**PLAN REVIEW SHEET**

Date: February 23, 2023

Petition #: RZP 2022-160

Address: 10837 Mt. Holly Rd.

RZ1.00

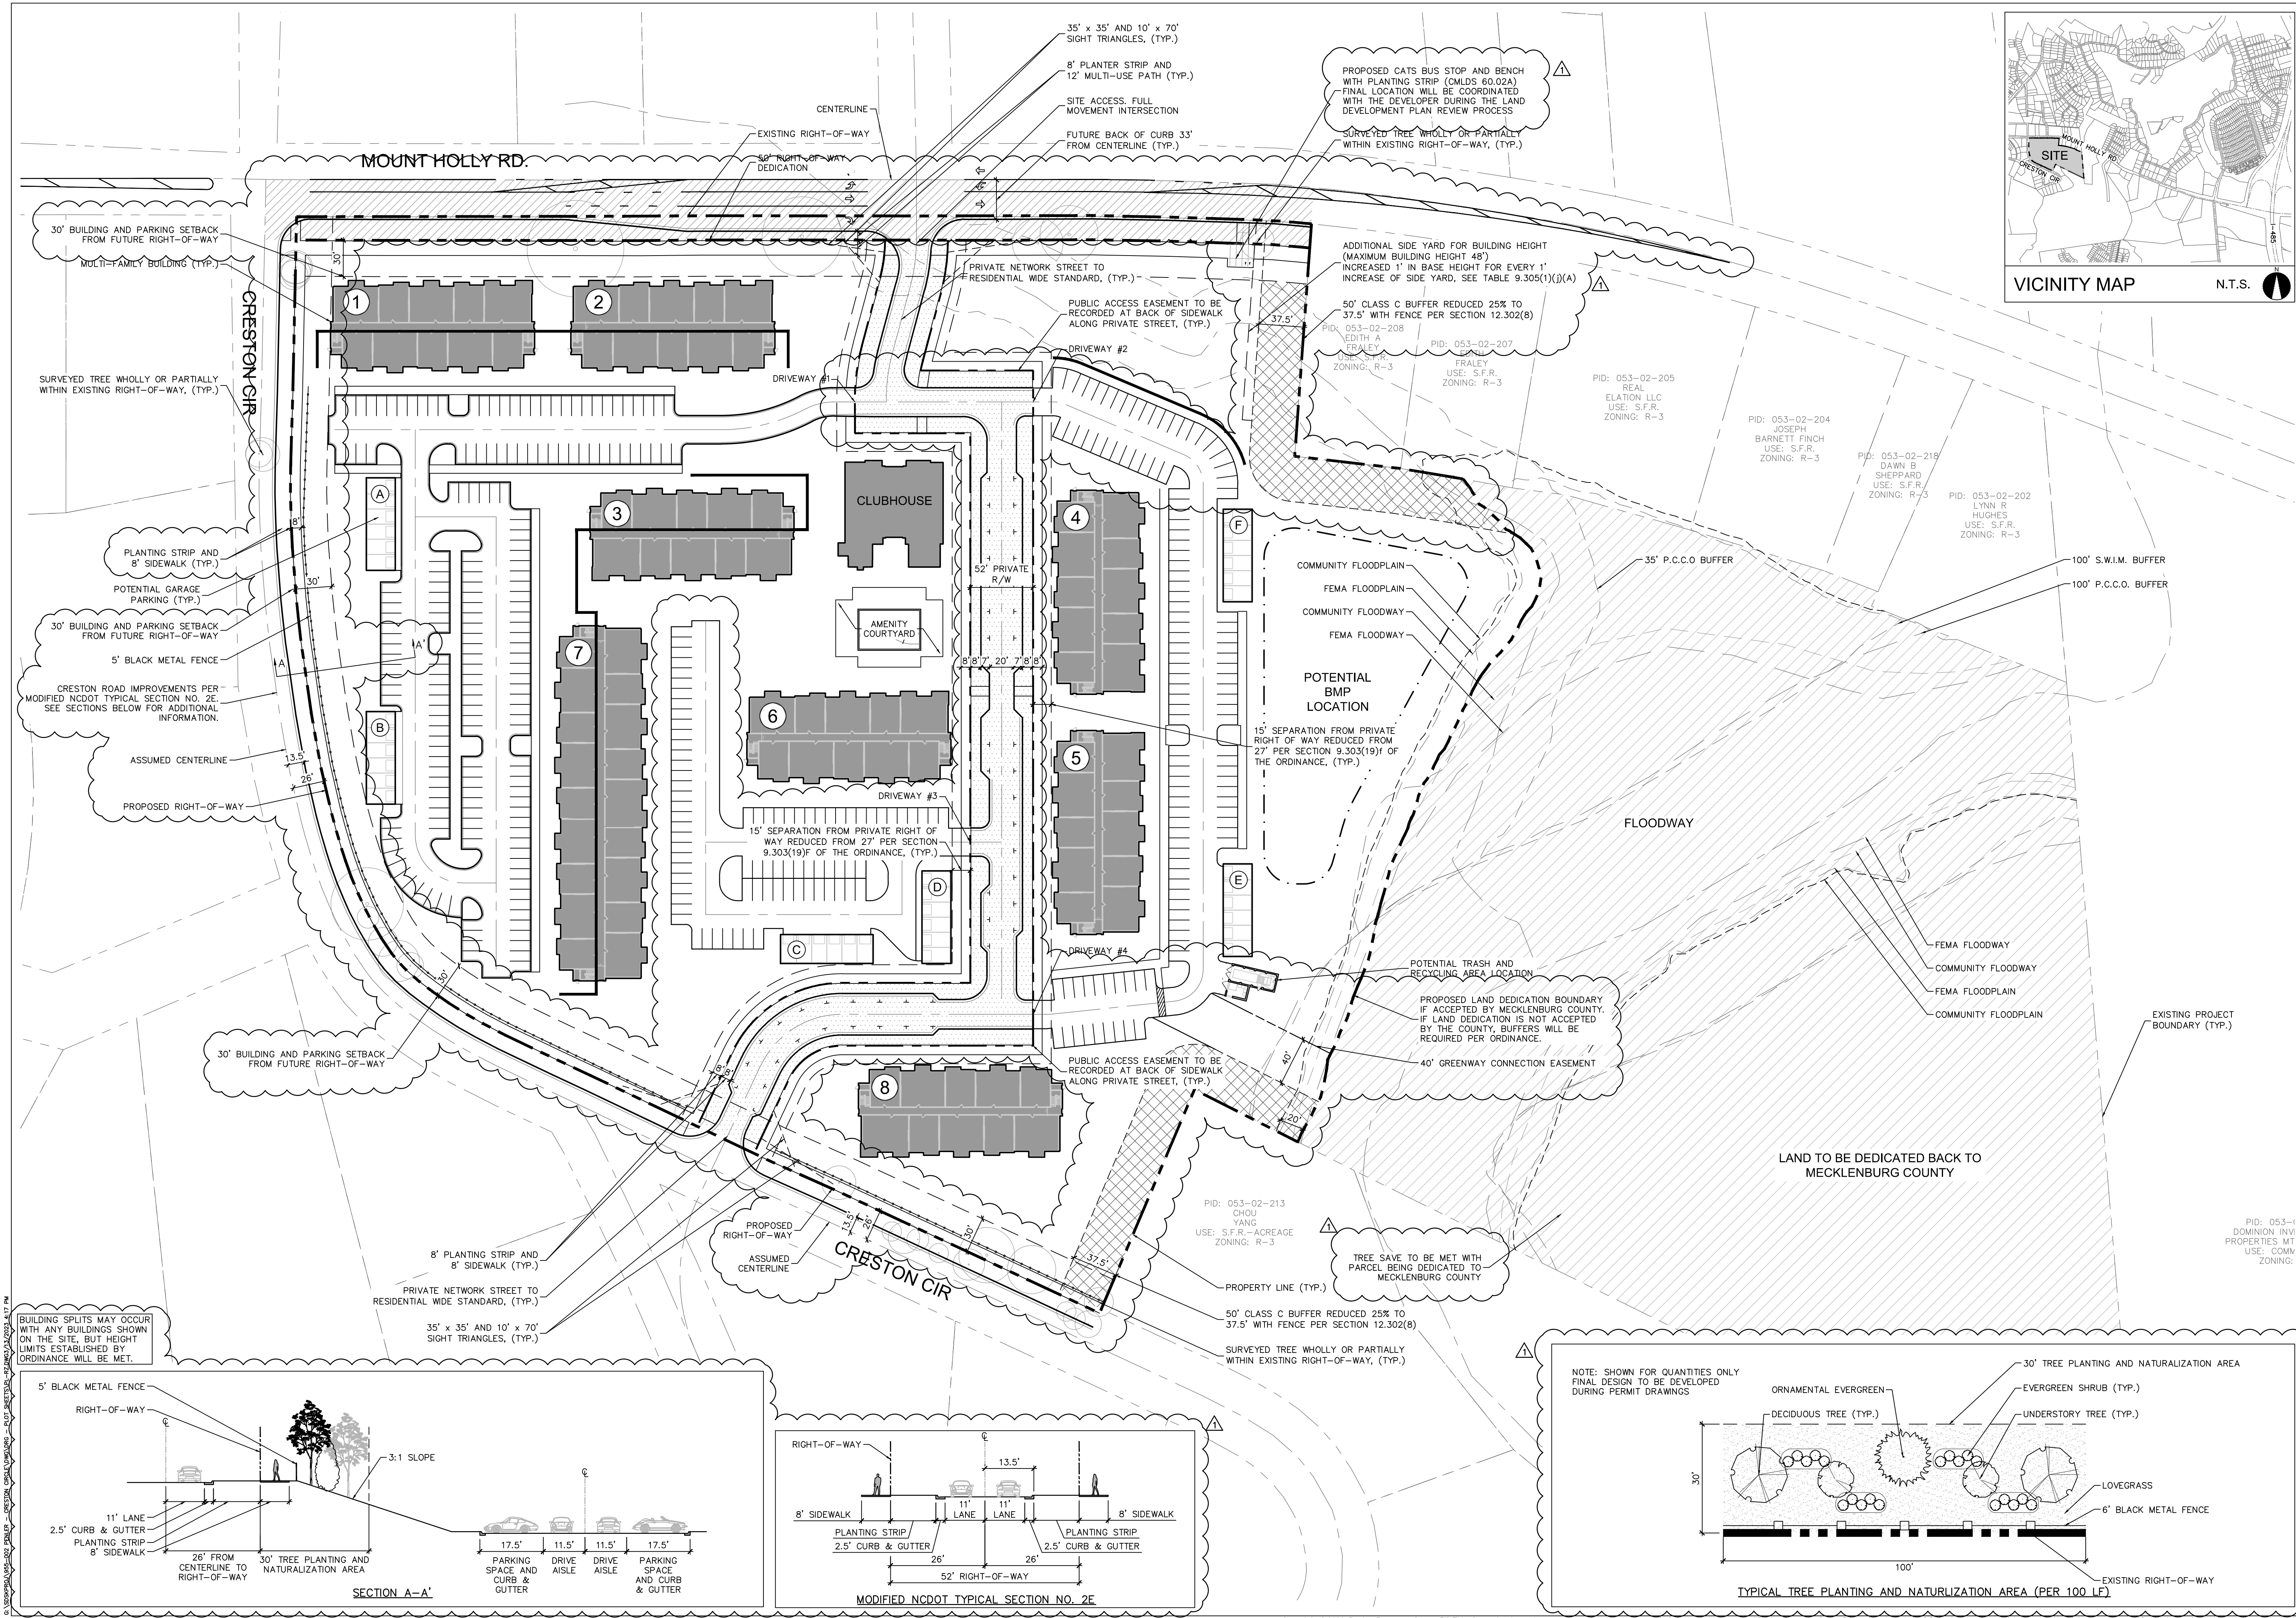
The site is located along CATS local bus route #18 on Mt. Holly Rd. CATS requests the construction of ADA compliant bus pad detail 60.02A along Mt. Holly Rd. The final location will be coordinated with the developer during the Land Development plan review process.
